CITY OF ALBUQUERQUE

**RE: The Varela Residence Volcano Cliffs Unit 18
6505 Pato Rd NW, S.A.D. 228, Lot 21 Block 6
Grading and Drainage Plan Date 12/27/16 (D10D003M21)
Pad Certification Date 1/25/17
CO Approval Date 6/2/2020
Revised G&D plan for pool Date: 3/20/2023**

C-1.0

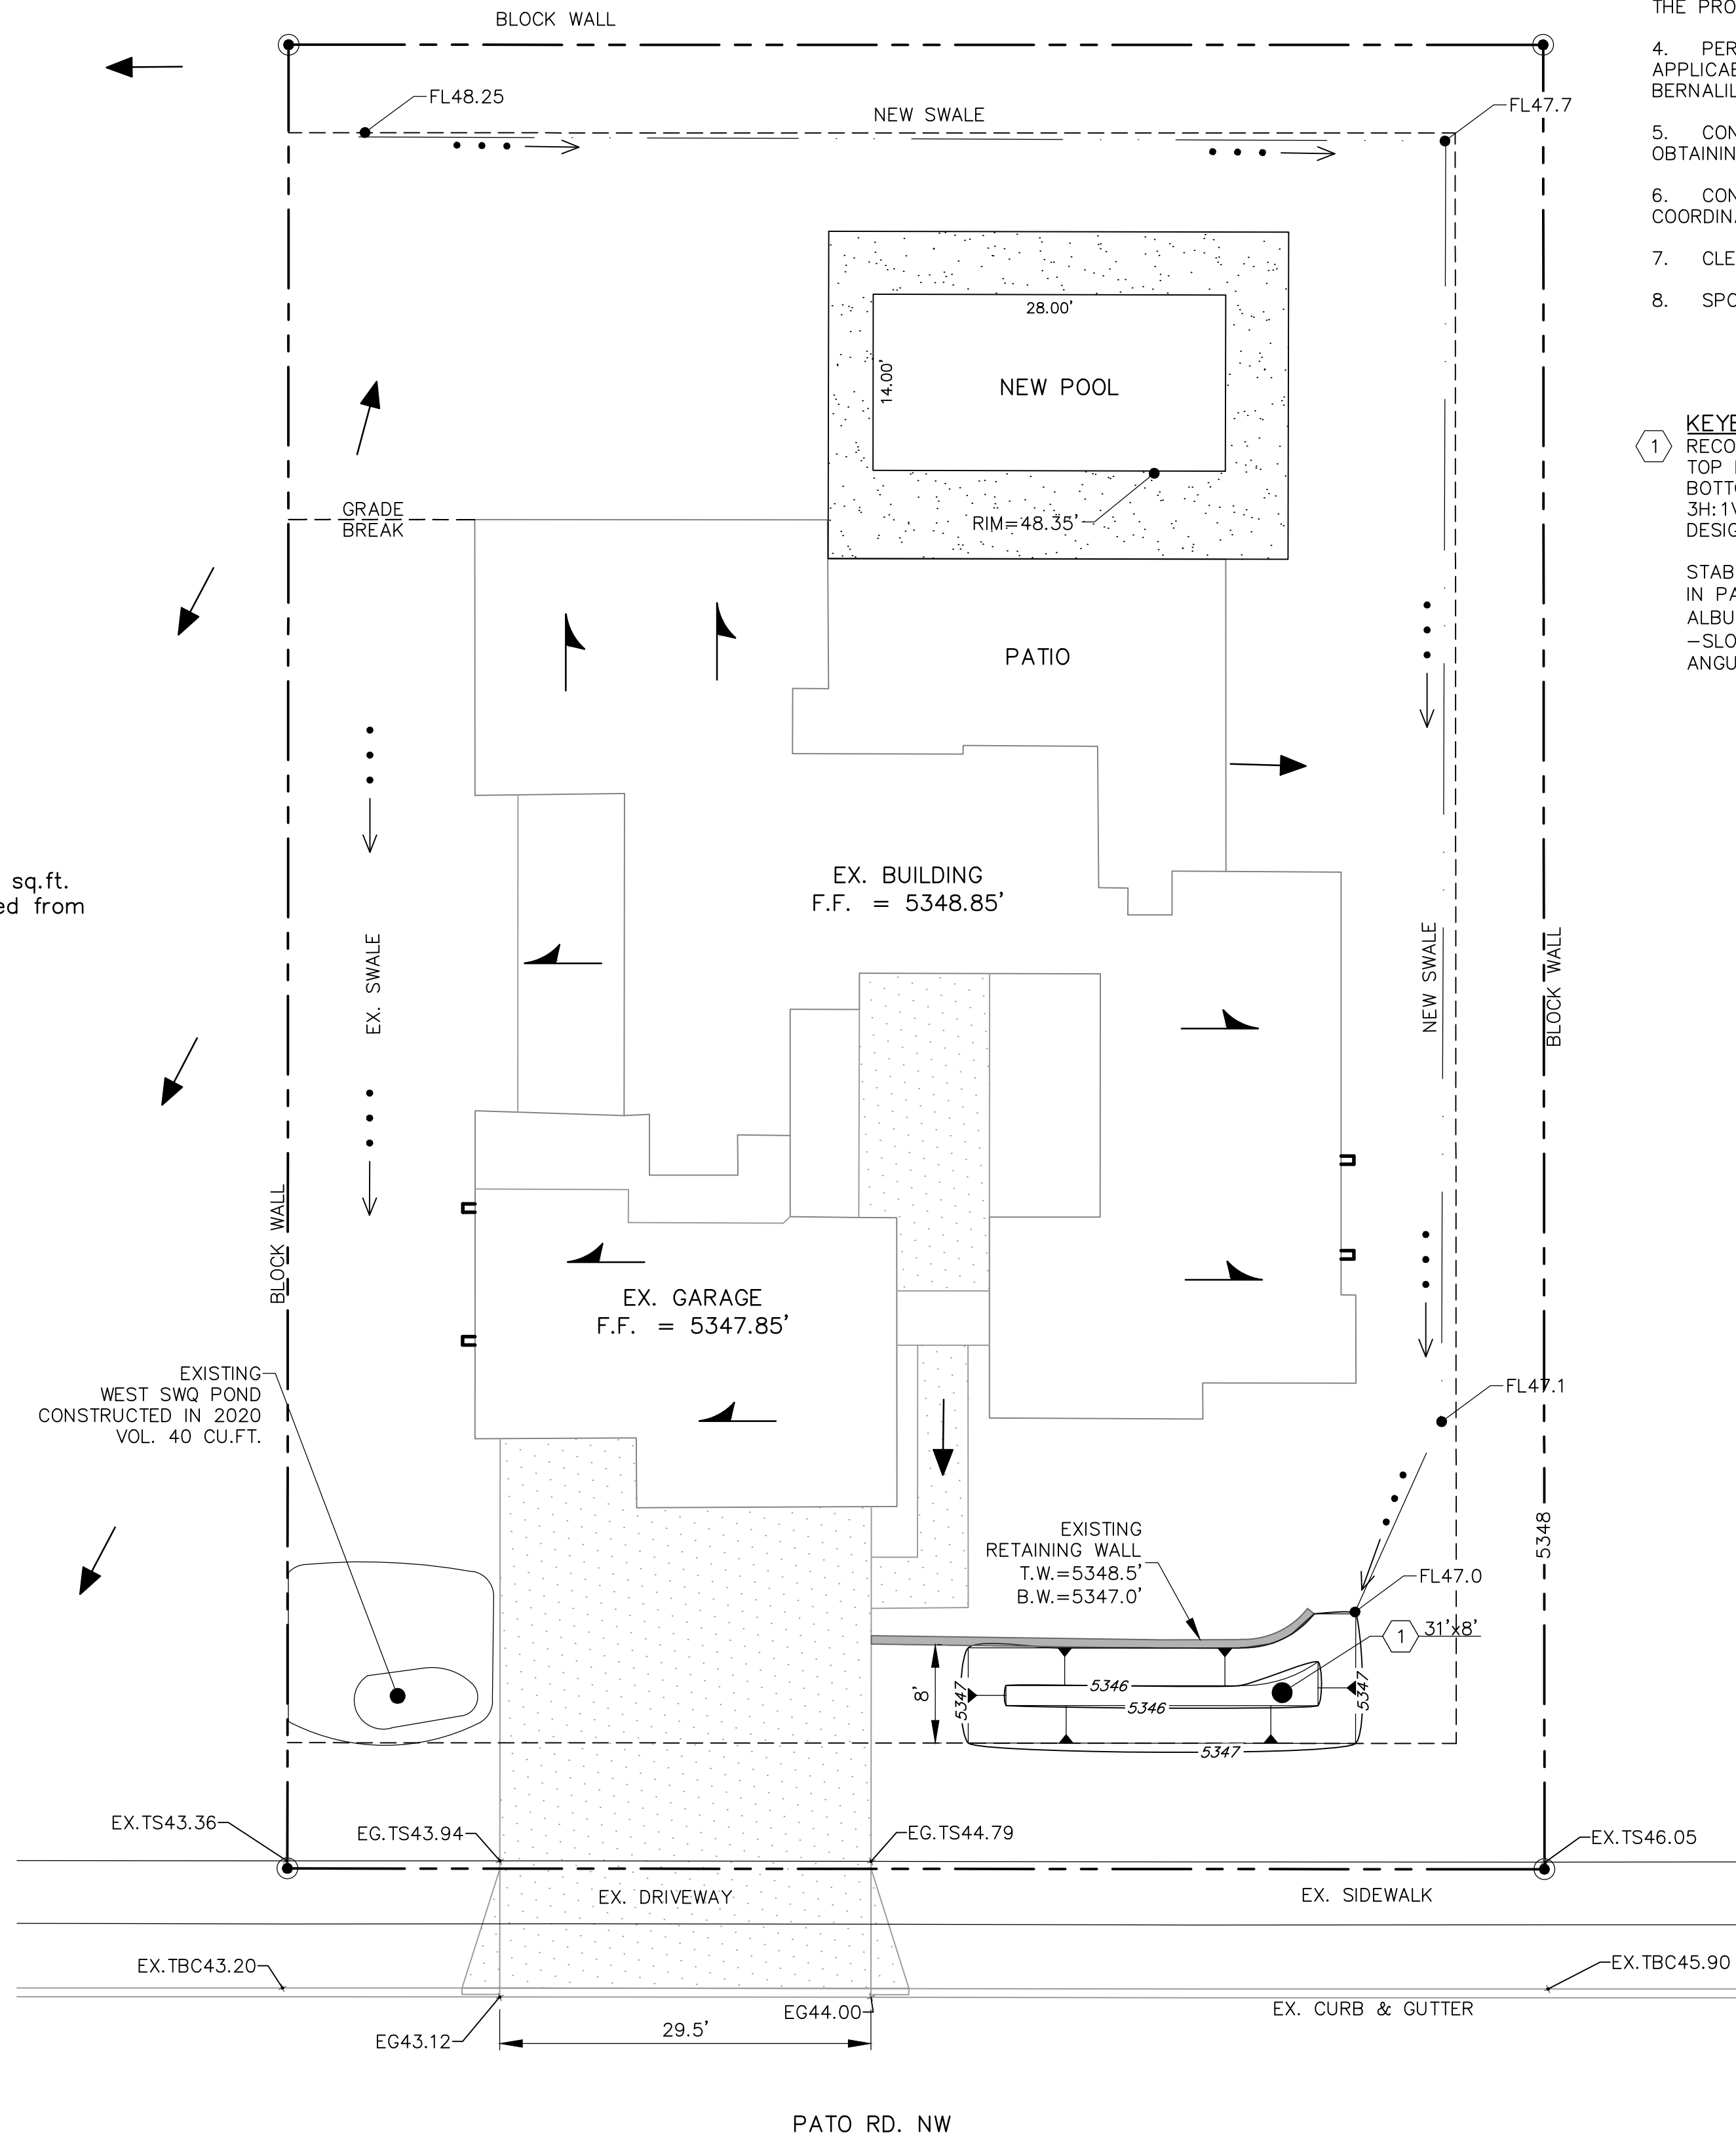
- Provide new land treatment amounts.
- Provide new pond size if needed.
